Subject: 9100 Florence NE (B20D024)

This email serves to notify you that the City of Albuquerque, Development and Review Department has reviewed the Amended Grading and Drainage Plan (Engineer's Stamp date 5-19-14) for the Property at 9100 Florence Ave. NE.

SUBJECT: 9100 FLORENCE AVENUE NE (B-20)

Permit: PWDN2014-0036

9100 FLORENCE AVENUE N.E. AMENDED GRADING AND DRAINAGE PLAN

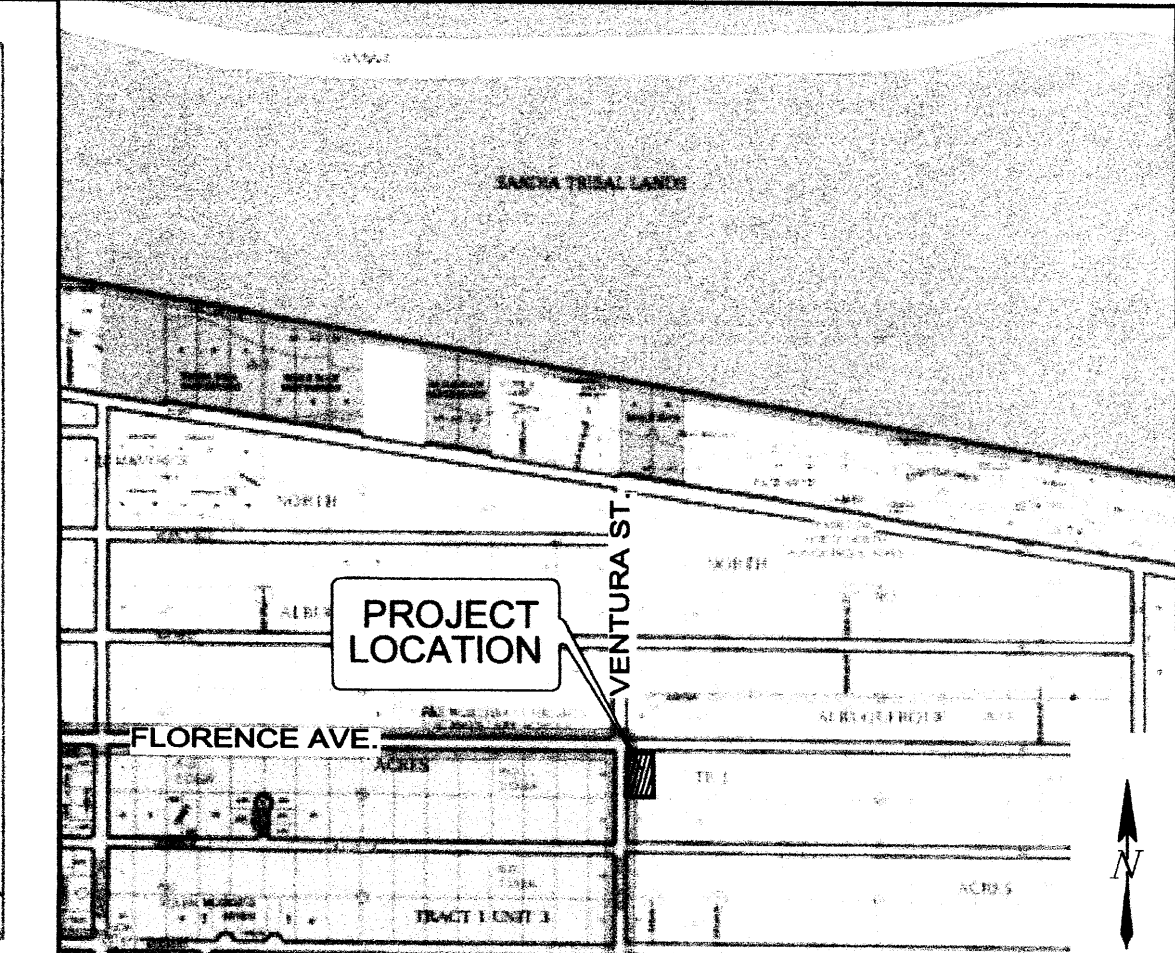
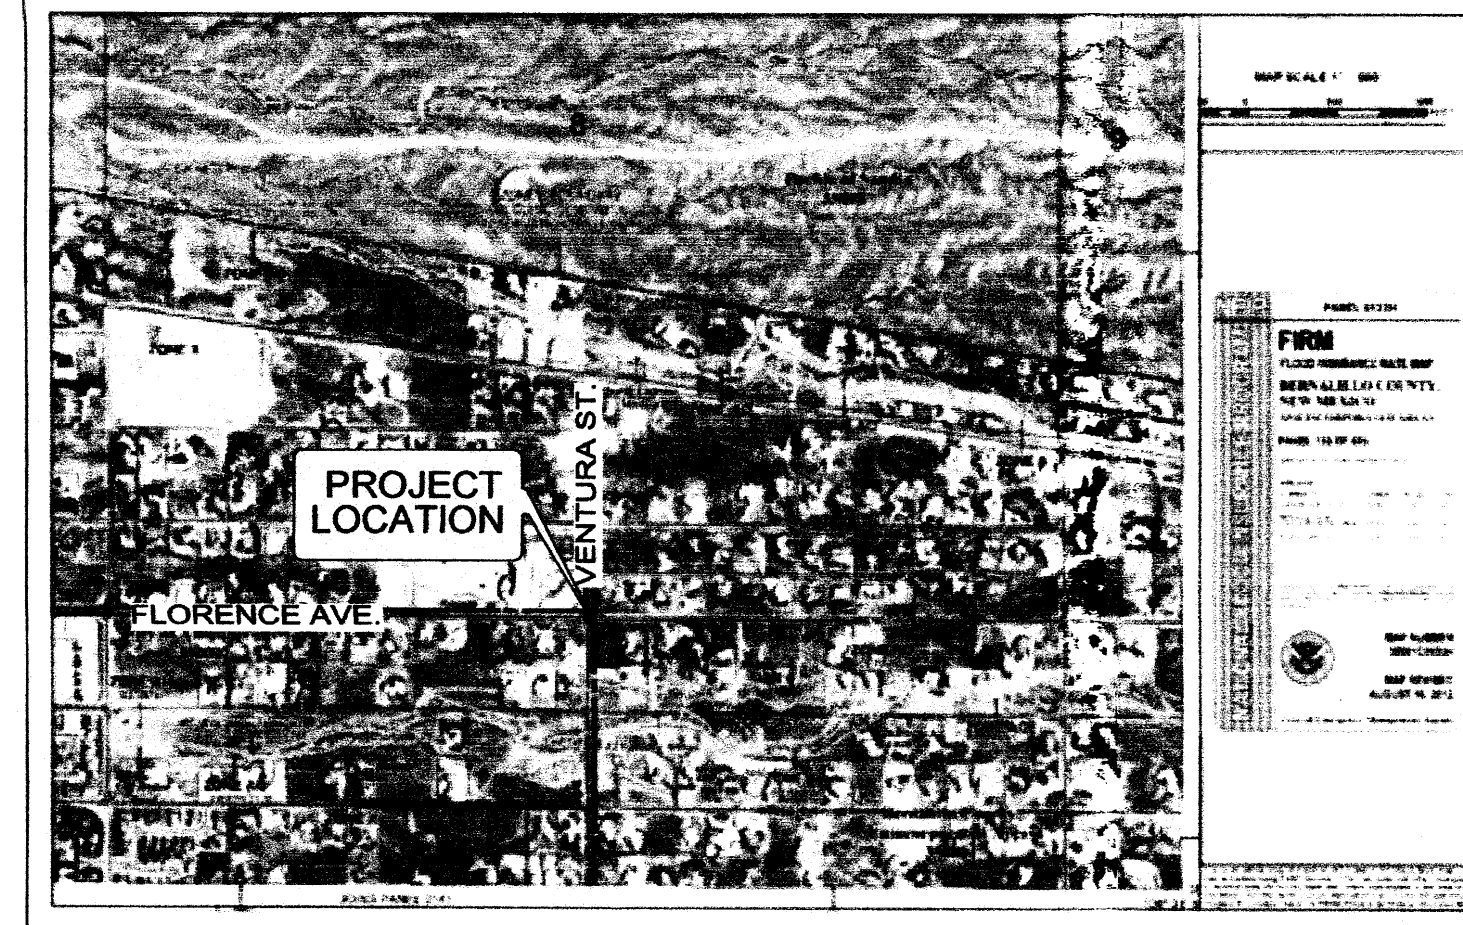
The discharge from the Proposed development is less than the existing conditions discharge. Therefore, the City takes no issue and accepts the proposed discharge from this site.

1) Please revise hydrology calculations based on an allowable 43, 20, 20, 17 land treatment balance for the A, B, C, D land treatments respectively.

2) As a protion of the lot drains to the City of Albuquerque right of way. Please provide a letter from the City indicating acceptace of this discharge.

Attached is the updated Grading and Drainage plan for the subject project. At your request, we have subdivided Basin 'B' in to 2 basins. Basin B-1 drains north to Florence. Basin B-2 drains to the ponding area located in the rear yard. Since Basin B-2 is a closed basin, the proposed peak developed flowrate existing the property into City ROW will be less than the existing condition.
